Rezoning Transportation Analysis
Petition Number: Insert Zoning Petition #2021-040
General Location Identifier: Tax ID 10505222

Date	Description
04.29.2021	First Review (WB)
05.27.2021	Second Review (WB)

Transportation Summary

CONCEPTUAL SITE PLAN
REZONING PETITION #2021-040
ED HODGES SITE
MATTAMY HOMES
CITY OF CHARLOTTE

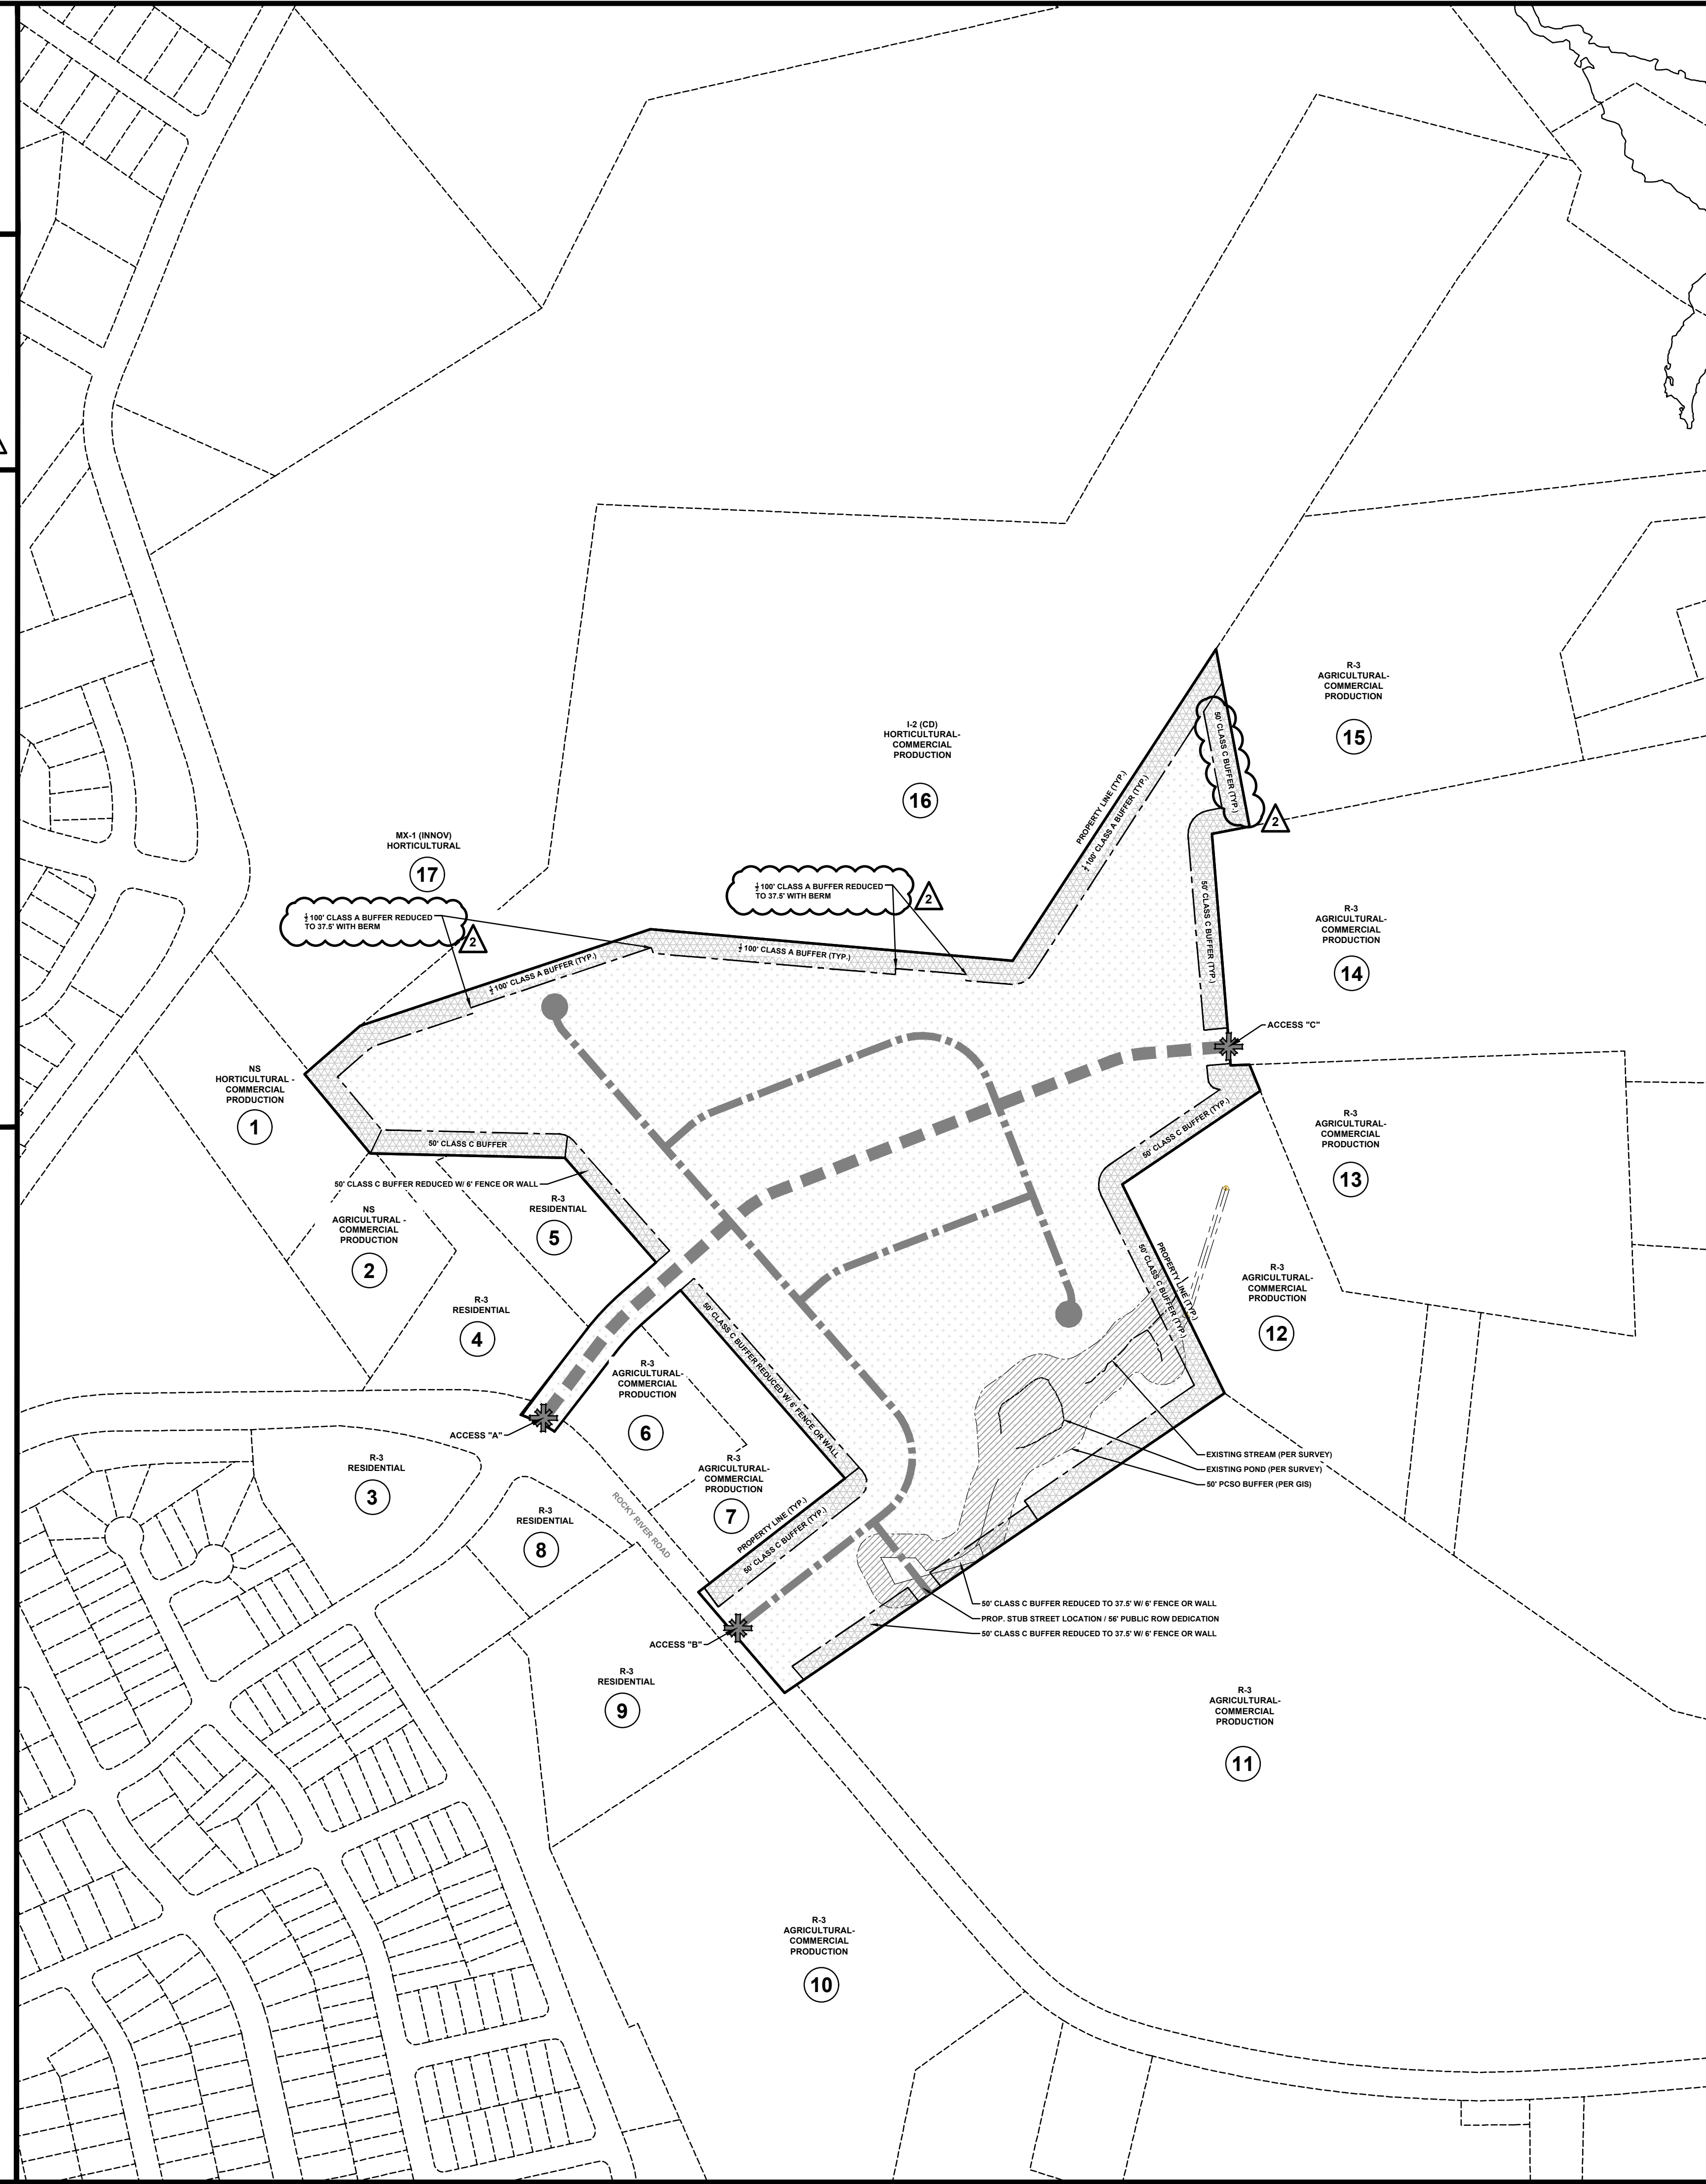
~~a. **Caldwell Road Extension (Recommended on CTP):** 2+ Avenue, Location of curb and gutter is 30' from the road centerline to the back of curb.~~

~~Label and dimension the curb and gutter from the centerline for each road on the site plan.~~

~~3. Revise site plan and conditional note(s) to commit to dedicate 78' right-of-way for the Caldwell Rd Extension (Recommended CTP alignment). The site plan shall label and dimension the right-of-way.~~

~~4. Revise site plan and conditional note(s) to commit to dedicate 50' right-of-way from the Rocky River Road centerline. The site plan shall label and dimension the right-of-way from the road centerline.~~

~~5. Revise site plan and conditional note(s) to commit to construct an 8-foot planting strip, and 6-foot sidewalk on Public Local Roads per Chapter 20. The site plan shall label and dimension both items from the back of curb and gutter.~~

~~6. Revise site plan and conditional note(s) to commit to providing a public street stub to the north per Chapter 20 (Subdivision Ordinance).~~

- ~~7. Site plan and conditional note(s) revisions are needed to commit to construct bicycle facilities by installing 12' multi-use paths per CLDSM 10.42 on both sides of the Caldwell Rd Extension, and along the site's frontage on Rocky River Road, to meet the City Charlotte BIKE Policy. The site plan shall label and dimension the multi-use paths from the back of curb and gutter.~~

- ~~8. Site plan and conditional note(s) revisions are needed to commit to realign Rocky River Road to provide a flatter horizontal curve meeting NCDOT Standards.~~

- ~~9. Revise site plan and conditional note(s) to commit to widen Rocky River Road at Caldwell Rd Extension to provide a left turn lane and a right turn lane into the development per NCDOT standards.~~

- ~~10. Revise site plan and conditional note(s) to commit to restrict the movement at new public street intersection to right turn-in, and right turn-out by installing a median that meets NCDOT standards. The median should not block access to the parcel across the street. The median should extend 50' past the tangent point on both sides of the driveway.~~

- ~~11. Site plan and conditional note(s) revisions are needed to commit to provide a 100' stem measured from the Rocky River Road R/W line per NCDOT Standards. No internal driveways are allowed within this stem.~~

- ~~12. Revise site plan and conditional note(s) to commit to widening Rick River Road to provide a right turn into the development at the new Local Road per NCDOT Standards.~~
